Request review of our minor subdivision to create 1 new lot from 3 existing lots and the vacated portions 6th Street NW and Prospect Avenue NW (1,839 sq. ft). We have approved variance applications for the side and rear setbacks of the existing property to be heard at ZHE on 4/18/23. Infrastructure list for frontage improvements is also provided.

Re: Preliminary / Final Plat Review for Proposed Subdivision of Lots 1 thru 3, Block 3 of Apache Trail and Approved Vacation of Portion of 6th Street N.W. Right-of-Way

The proposed replat and vacation was heard at DRB for sketch review on July 27th, 2022, under project number PR-2022-007348, and the vacated portion of 6th Street was approved at a DHO hearing on April 26th, 2023. The comments from that sketch review are addressed below:

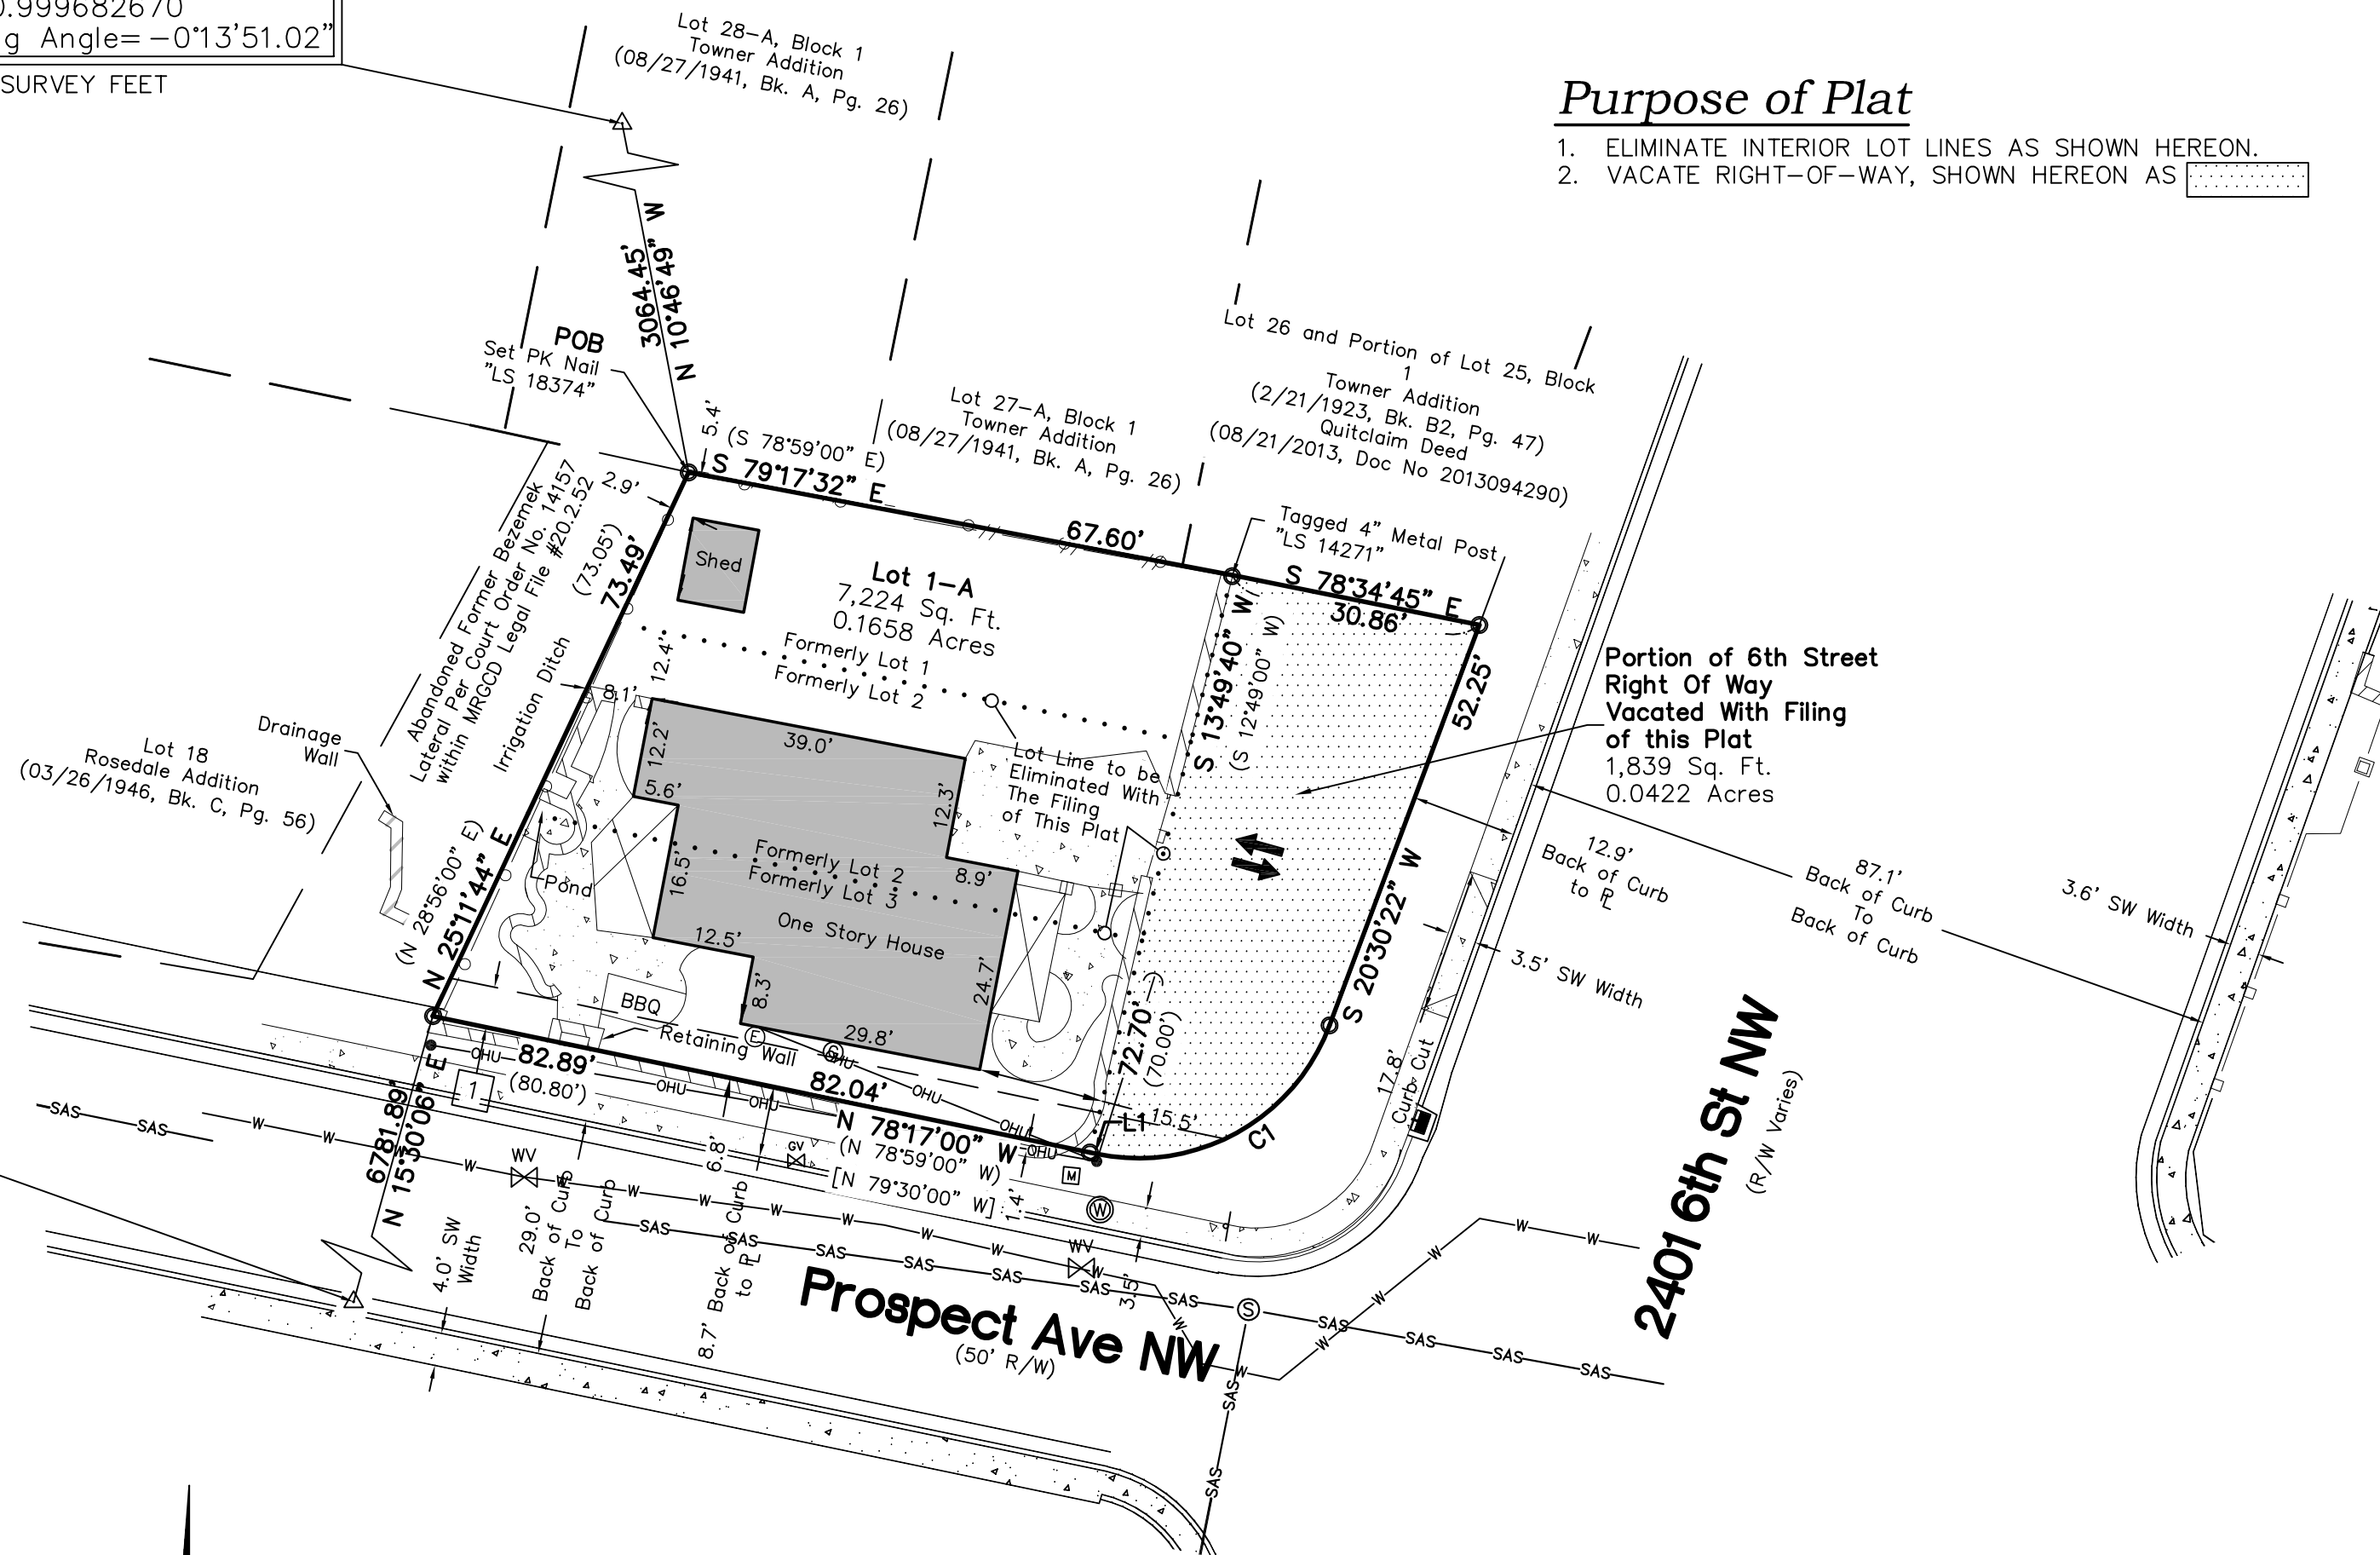
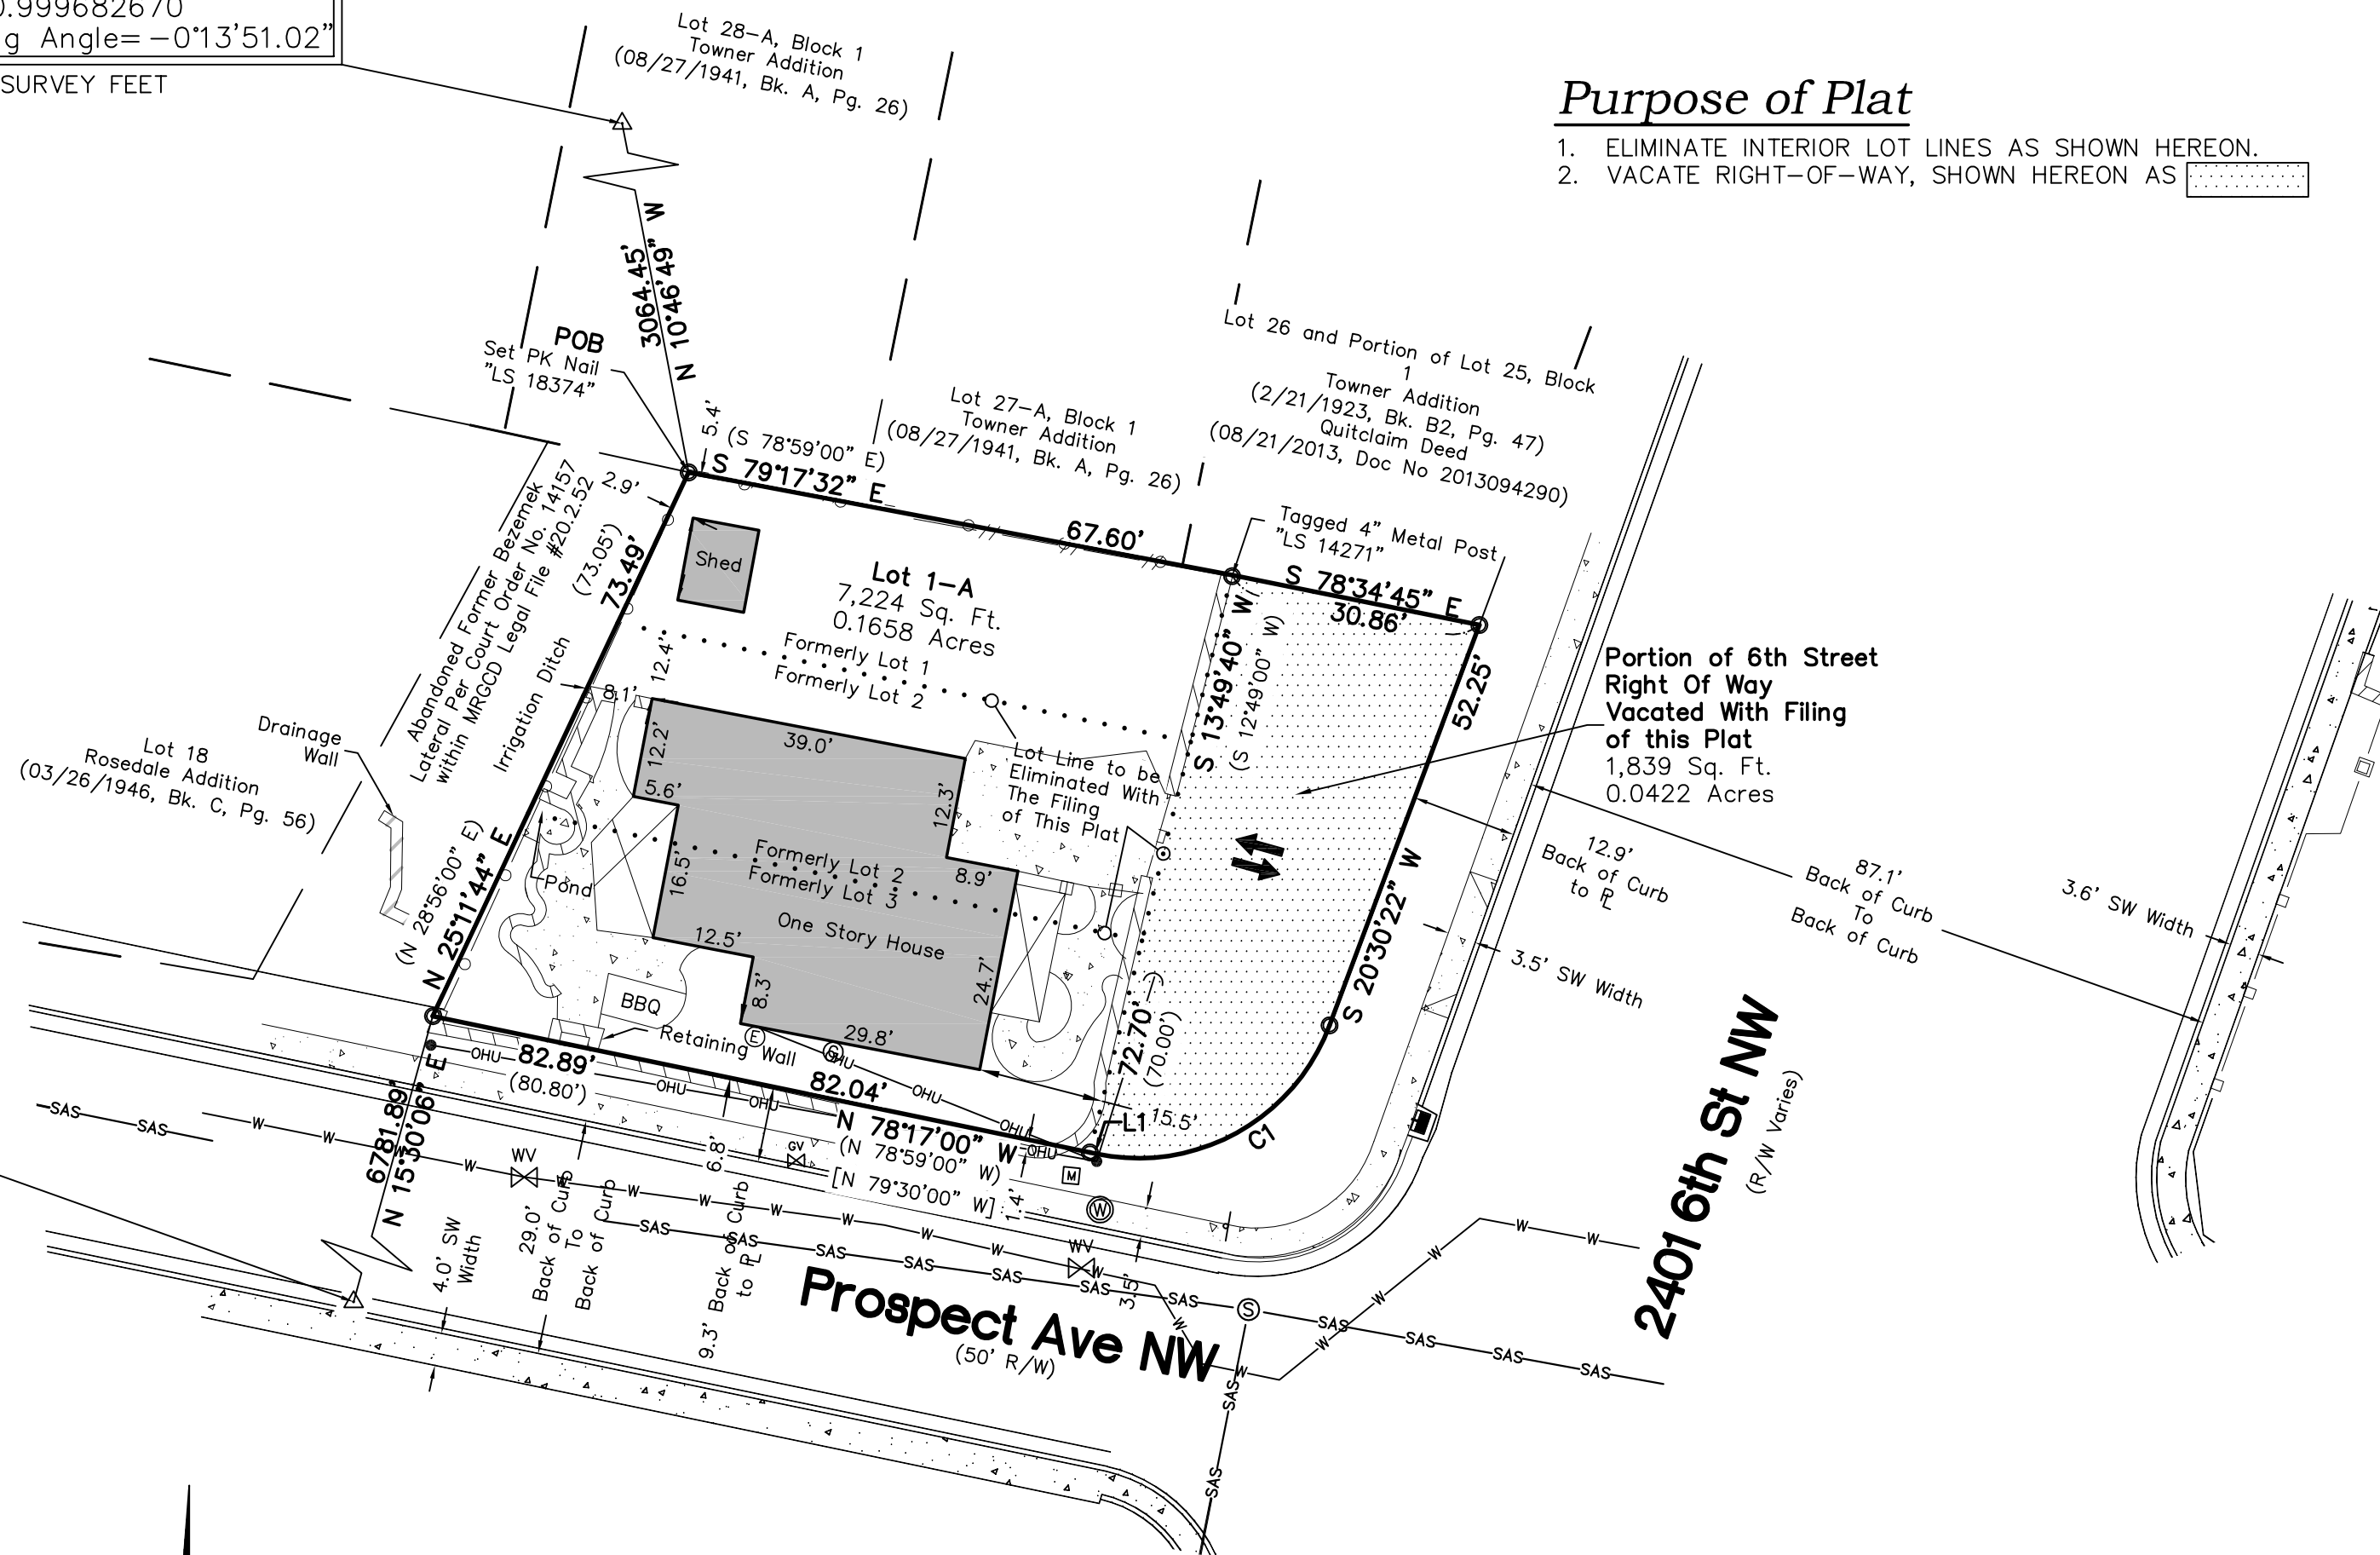
Noted, we have notices of decision dated May 3rd 2023 for the approved variances from the ZHE for side and rear lot setbacks, which were heard on April 18th, 2023. This is noted on our proposed plat sheet 2.

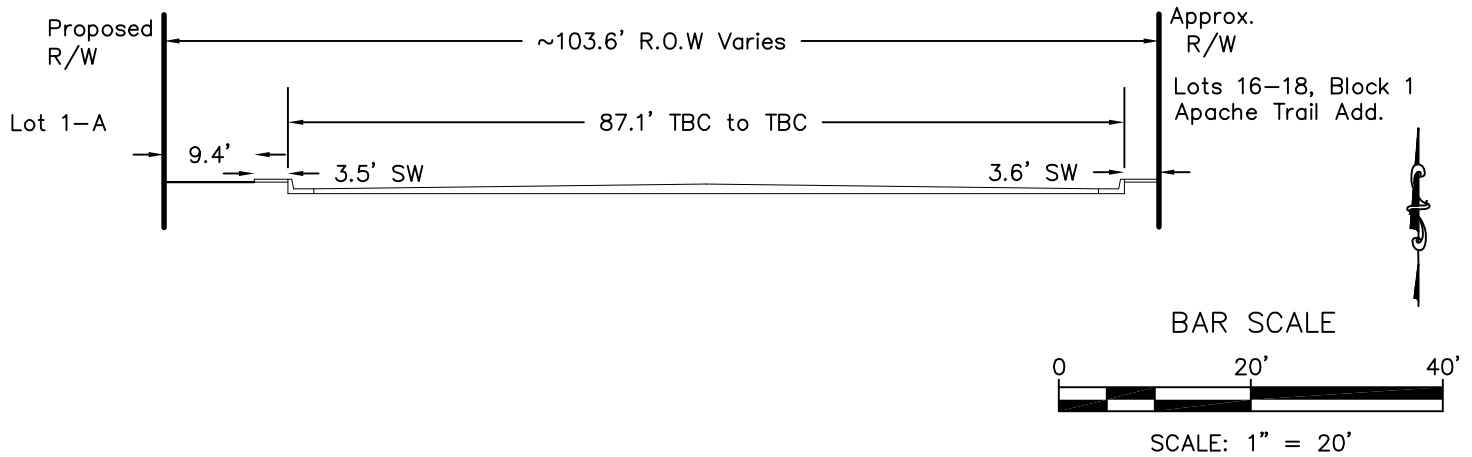
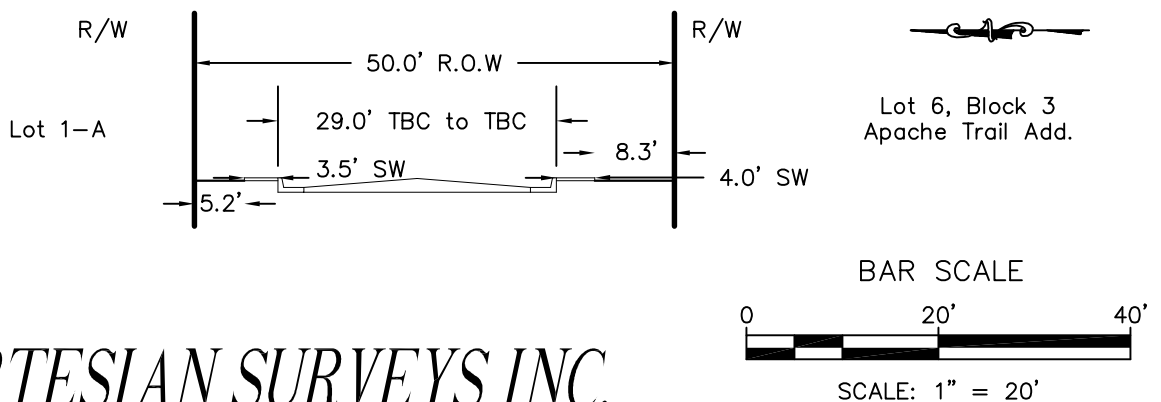
1. 6th St. is a Principal Arterial and requires 6' sidewalk with a 5-6' landscape buffer. Prospect Ave. is a Local street and requires 5' sidewalk with a 4-6' landscape buffer. From the cross sections provided it appears that ROW dedication will not be needed to achieve this. Please add these items to an infrastructure list which must be financially guaranteed. Other than this, Transportation has no objection to the vacation.

Noted, see attached infrastructure list and cross-section for the 6th Street and Prospect Ave rights-of-way, and curb cut along 6th Street NW.
